DATE: March 26, 2019
TO: Kari Parsons, PCD-Project Manager
FROM: Jeff Rice, PCD-Engineering
SUBJECT: SP-18-004 – Redtail Ranch
Fourth Submittal

NES and
CCES Responses

ENG-SP18004-R4-PDRFDR-redlines.pdf Markup Summary

**RETAIL RANCH**  
PRELIMINARY/FINAL DRAINAGE REPORT  
DEVELOPED DRAINAGE MAP

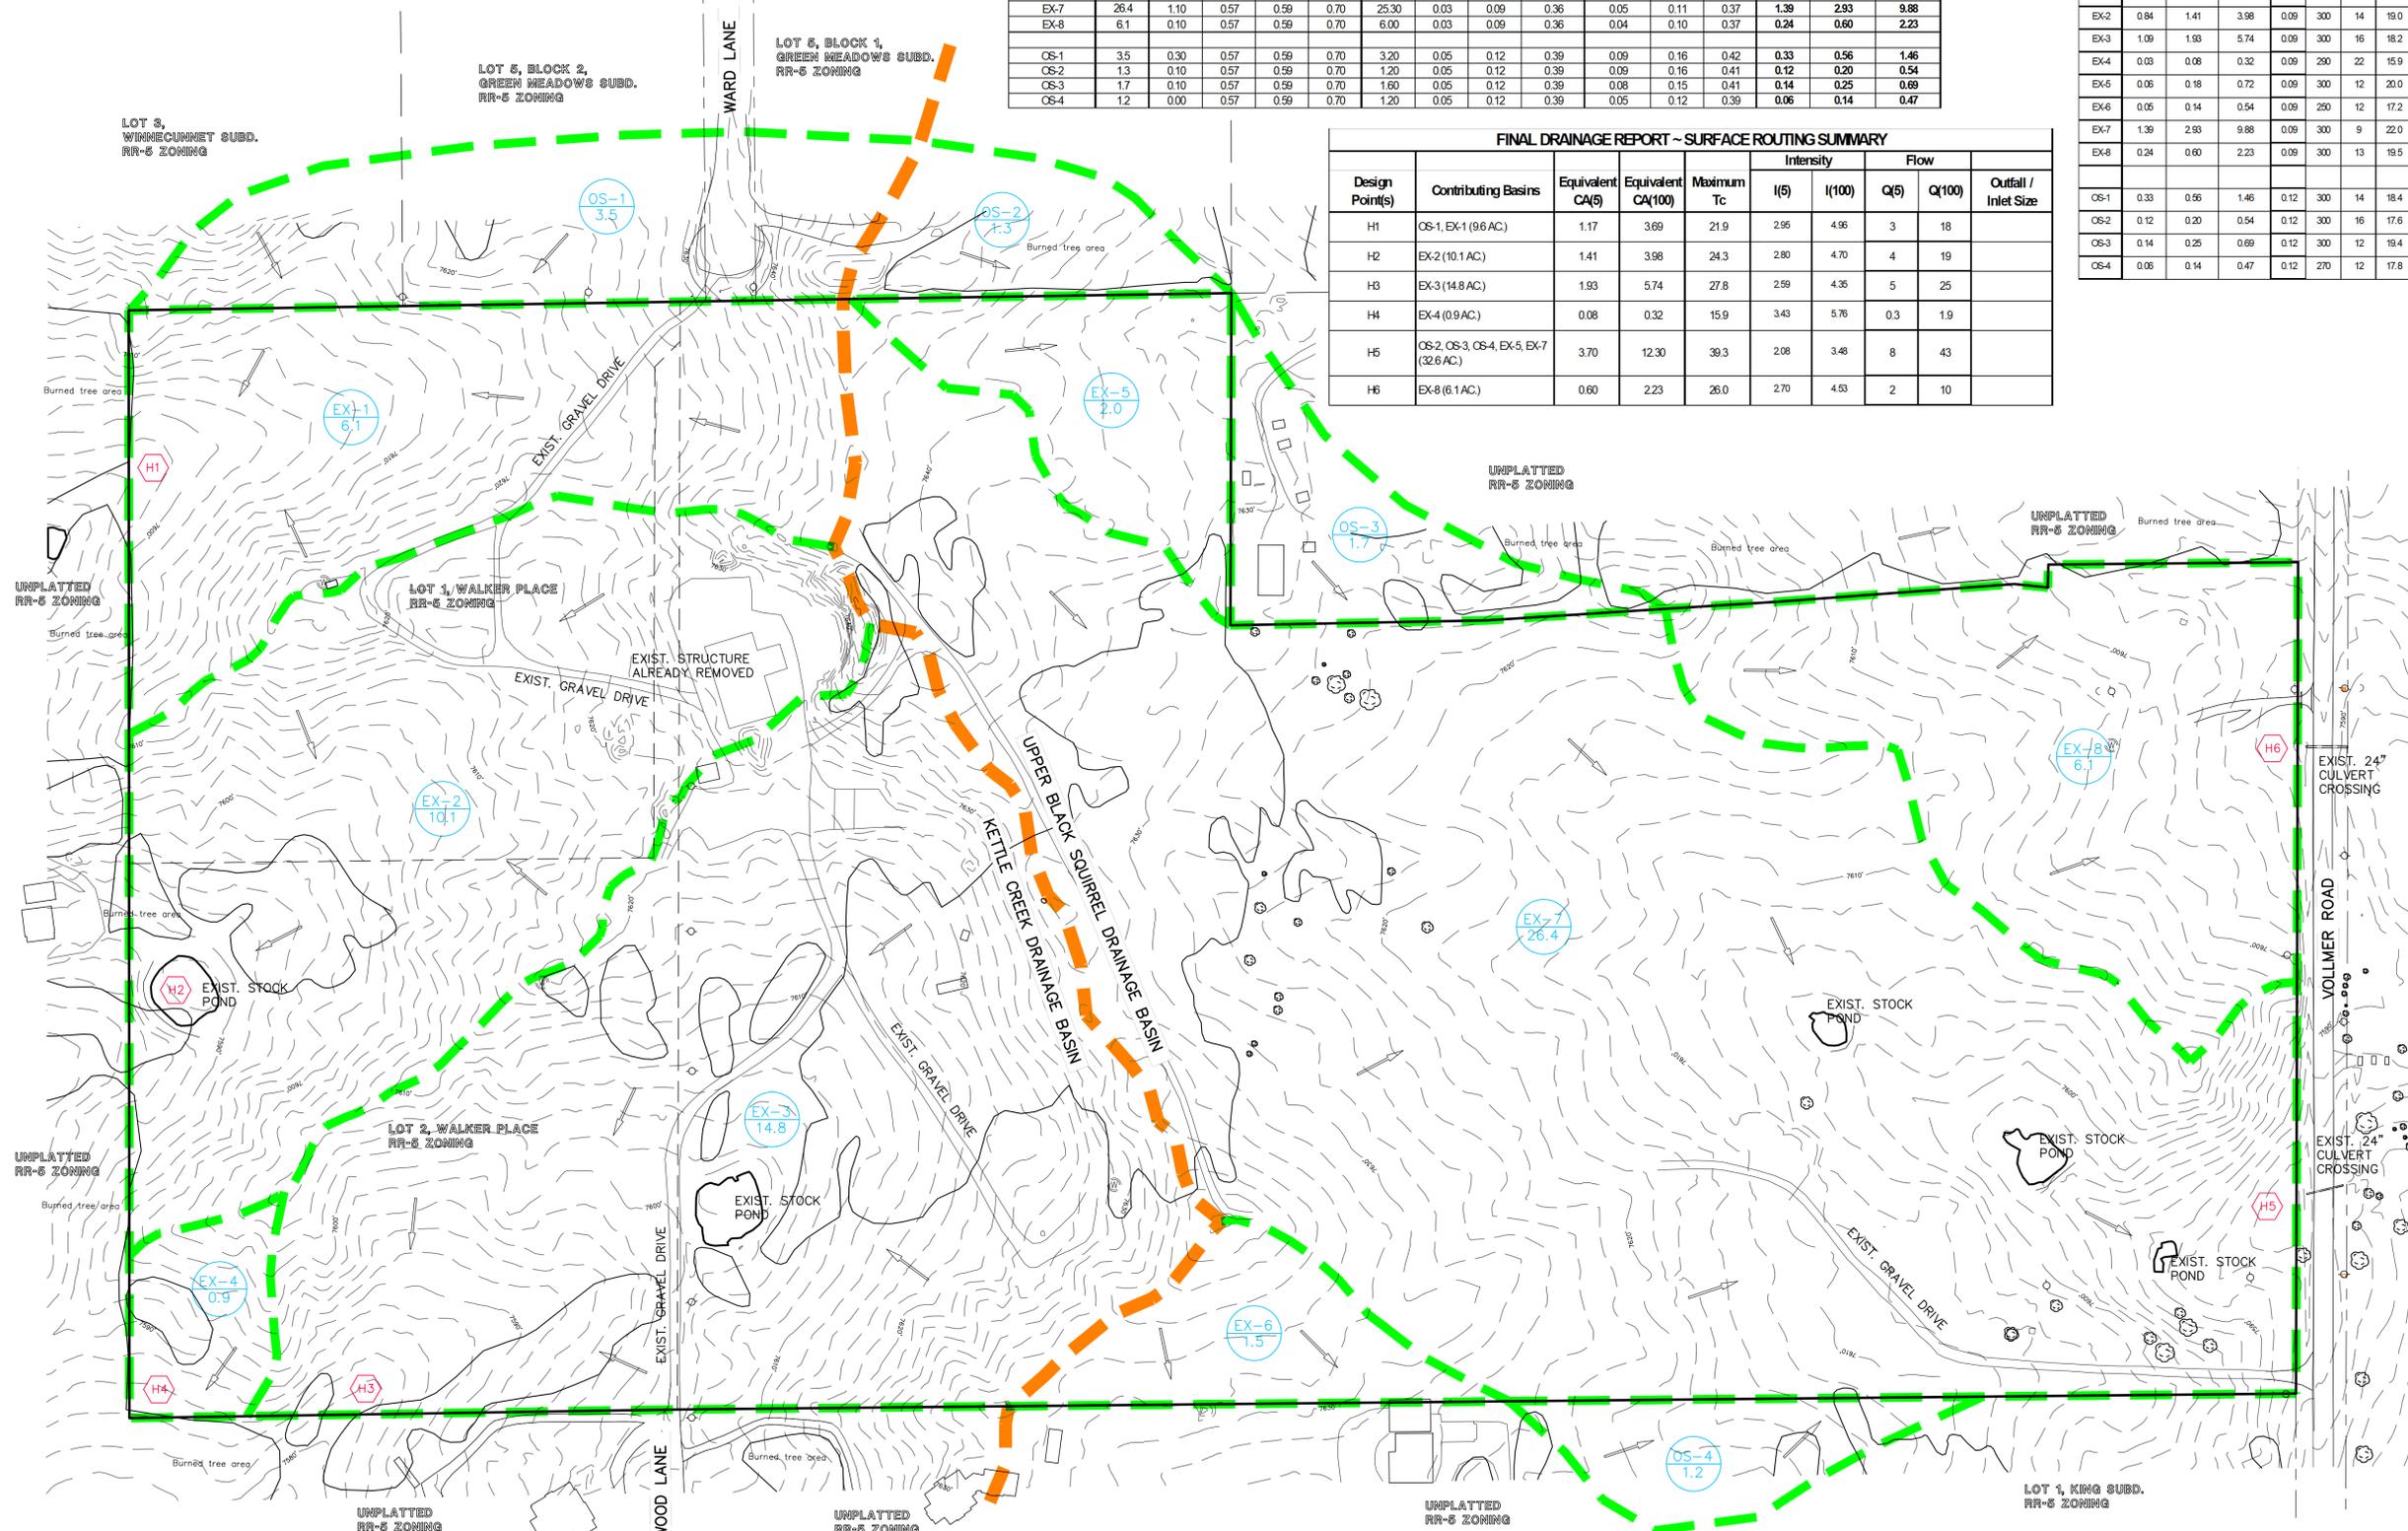
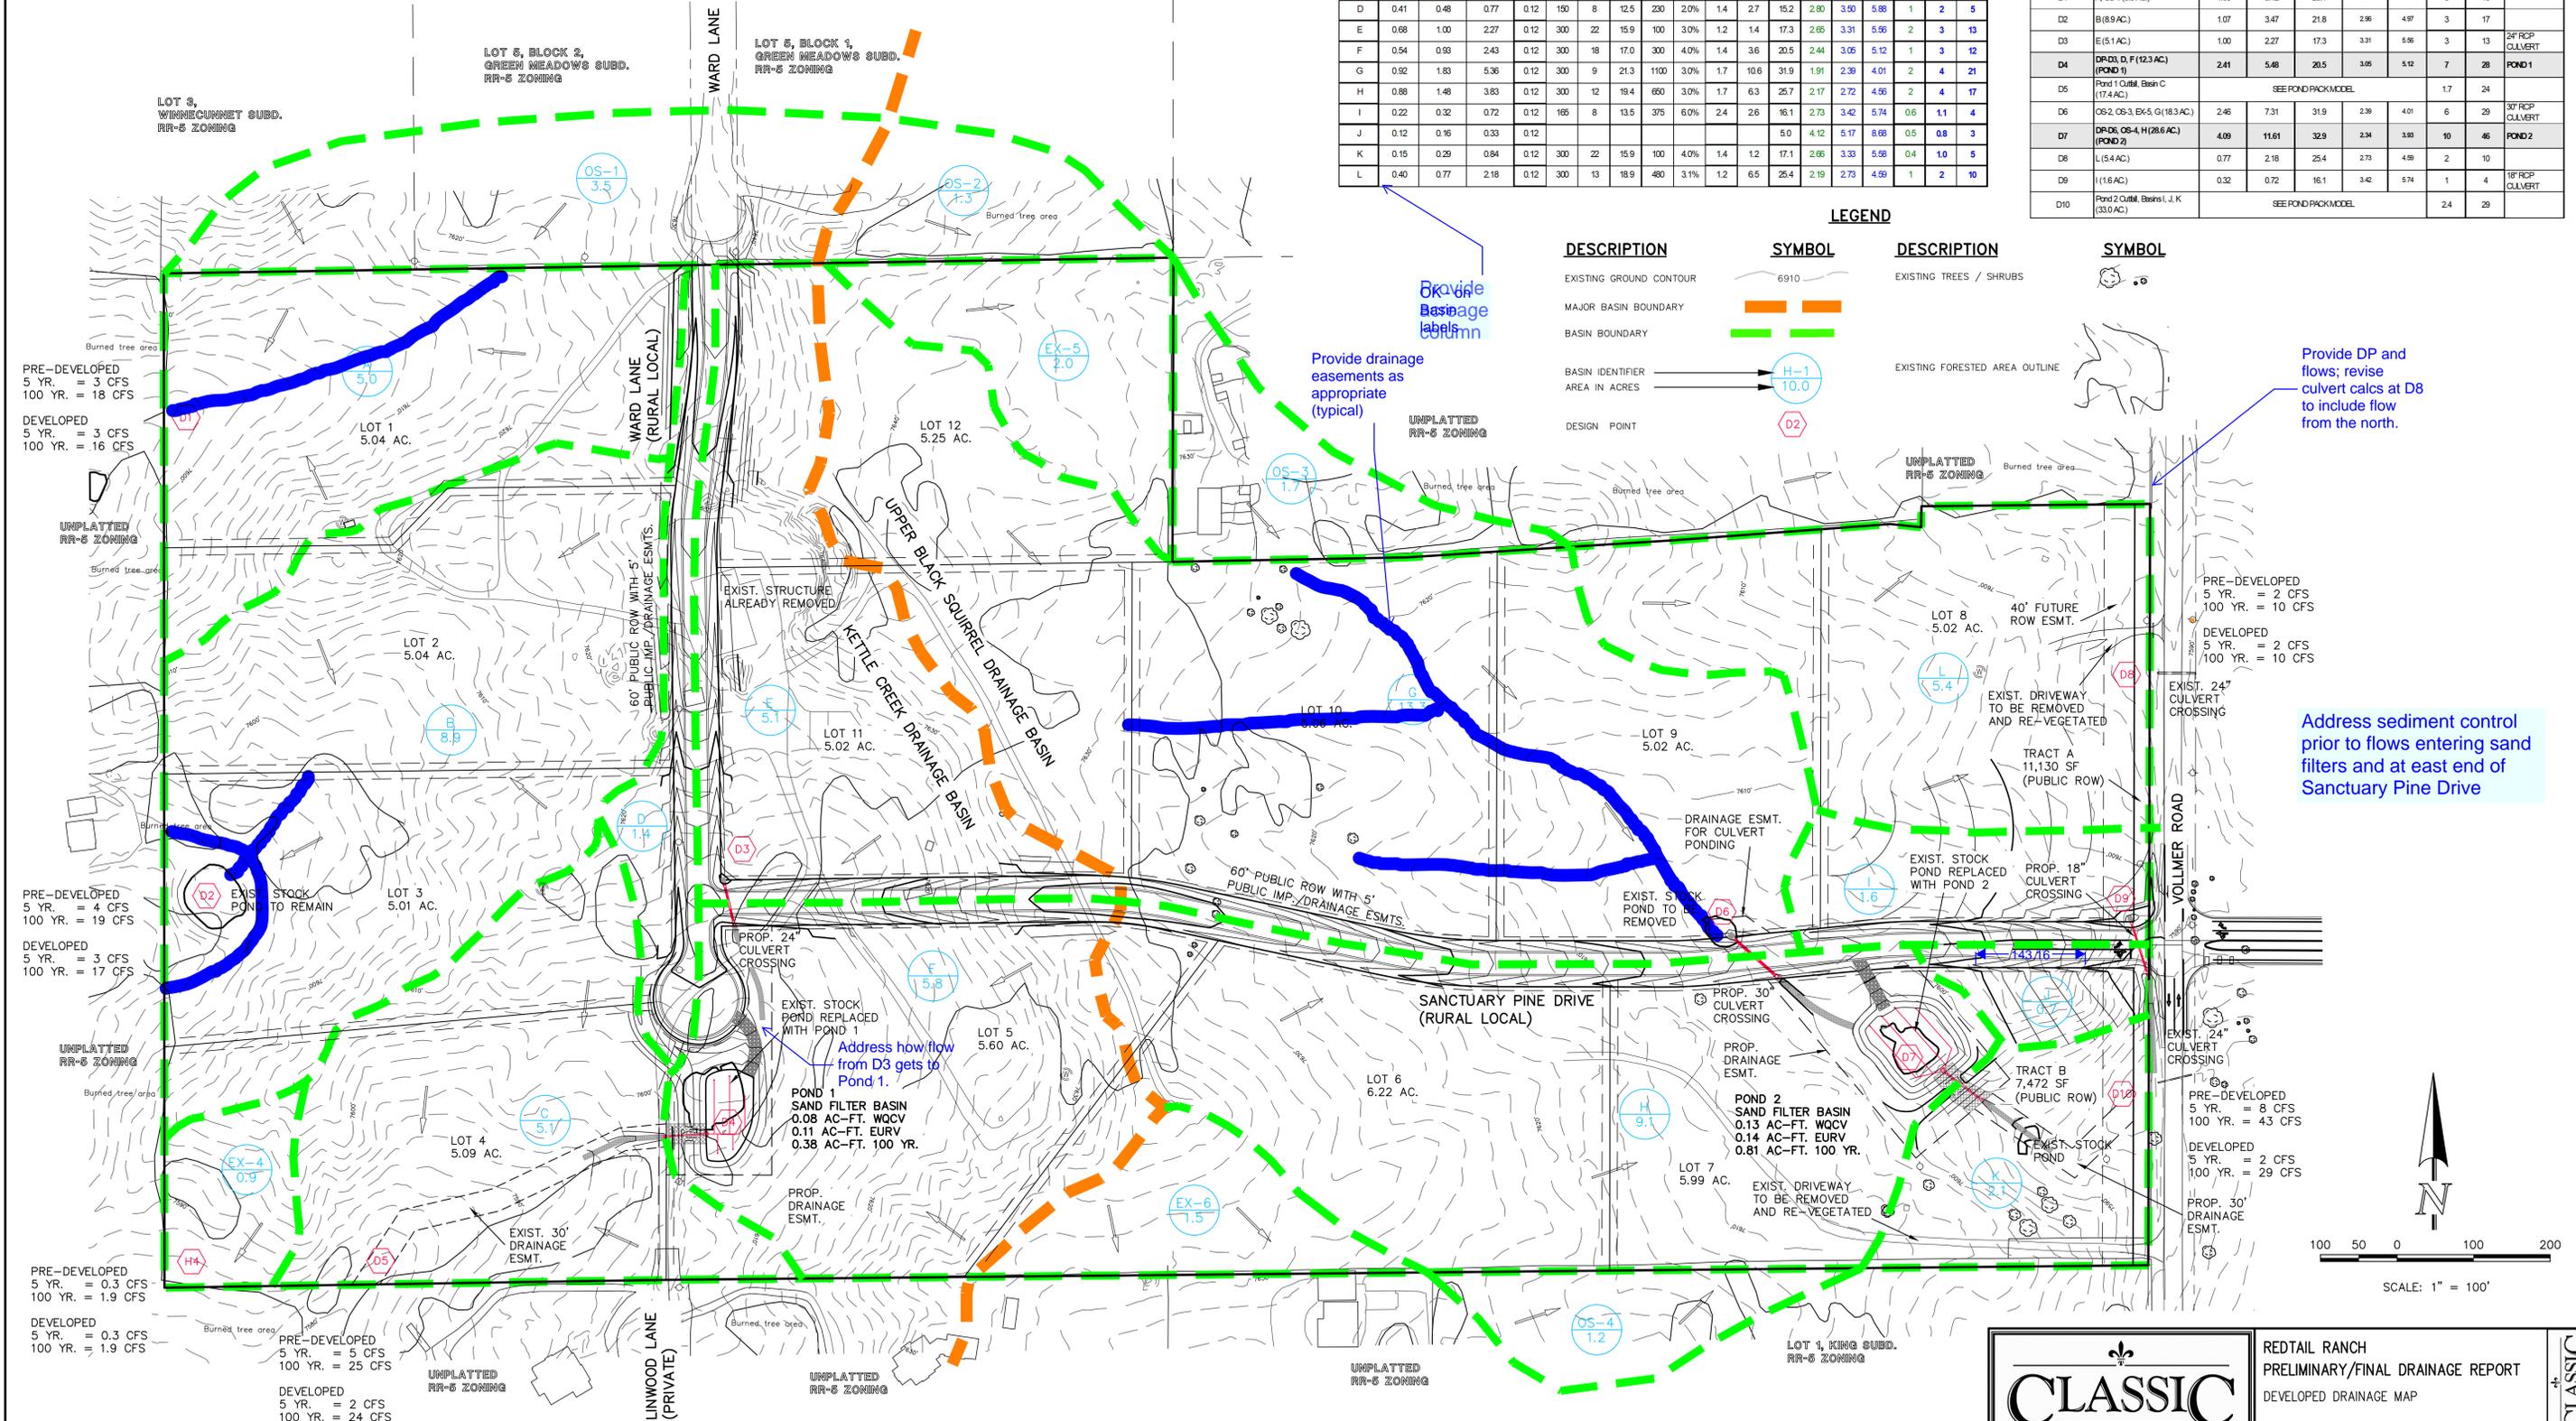
3. *through 6 – Resolved.*
7. Add the offsite basins for Vollmer Road flowing along its west side, and culvert analyses for the existing and proposed culverts intercepting these flows. Unresolved (redline added). **Partially resolved; provide the culvert analysis for D8 with total flow. Unresolved.** *now included*
8. **Resolved.**
9. See PDR and plan redlines for additional comments. Partially resolved; see remaining/updated redlines. *See remaining/updated redlines.* **See remaining/updated redlines.** ✓

Does this culvert need to be modified?

No. with proposed upstream SF Basin and full-spectrum design, developed flows are less than pre-dev.
